Item No. Report of the Interim Director of Planning, Regeneration & Public Realm**Address** 60 HIGH STREET RUISLIP**Development:** Change of use of the upper floors of existing retail unit as 2 flats (Schedule 2, Part 3, Class G of the Town and Country Planning (General Permitted Development) (England) Order 2015 (as amended).**LBH Ref Nos:** 4131/APP/2022/3240**Drawing Nos:** HSR.60.EX.01 (received on 24.11.2022)
HSR.60.EX.02 (received on 24.11.2022)
HS.60.EL.01
HSR.60.PR.02
Site Location plan
HSR.60.PR.01**Date Plans received :** 21/10/2022**Date(s) of Amendment(s):****Date Application Valid:** 21/10/2022**1. SUMMARY**

Prior approval is sought for the change of use of the upper floors of an existing retail unit to 2 flats (Schedule 2, Part 3, Class G of the Town and Country Planning (General Permitted Development) (England) Order 2015 (as amended). This application is a re-submission since the refusal of prior approval application 4131/APP/2022/2468 (refer to section 3.3 for further details).

Project: 60 High St Ruislip, London HA4 7AA		
Title: PROPOSED Floor Plans		
Date: 15.09.22	Scale: 1:100 @ A3	
Dwg. No. HSR.60.PR.01	Rev:

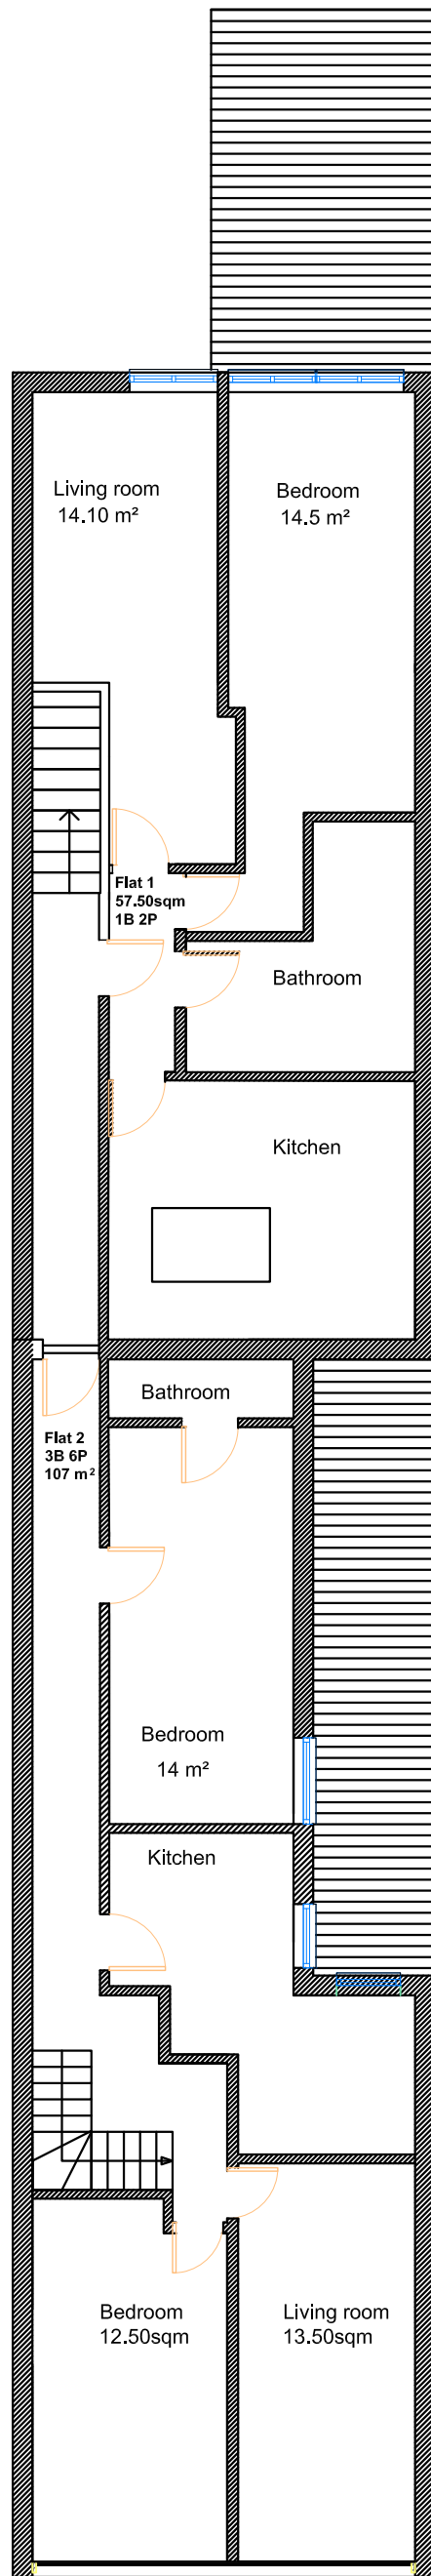
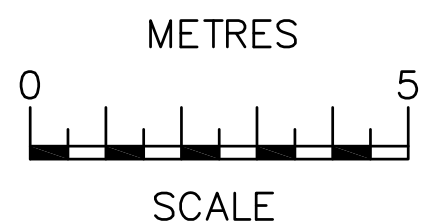
YES- Drawing no. HSR.60.PR.01 indicates this.

YES- Drawing no. HSR.60.PR.01 indicates this.

YES- Drawing no. HSR.60.PR.01 and HSR.60.PR.02 indicates this.

A daylight and sunlight assessment has not be submitted with the application. For guidance purposes, Annex 3 Glossary of the London Plan defines a habitable room as "any room used or intended to be used for sleeping, cooking, living or eating purposes." Based on this definition, the kitchens serving Flats 1 and 2 would constitute as a habitable room. The kitchen serving flat 1 would have no windows. The side windows serving a double bedroom and kitchen within Flat 2 would face directly towards the adjoining building at No. 58. Furthermore, the front bedroom at second floor level would only be served by roof lights. It has therefore not been demonstrated that the proposal would provide an adequate provision of natural light in all habitable rooms of the proposed flat, contrary to criterion G.1 (d)(iv), Class G of the GPDO.
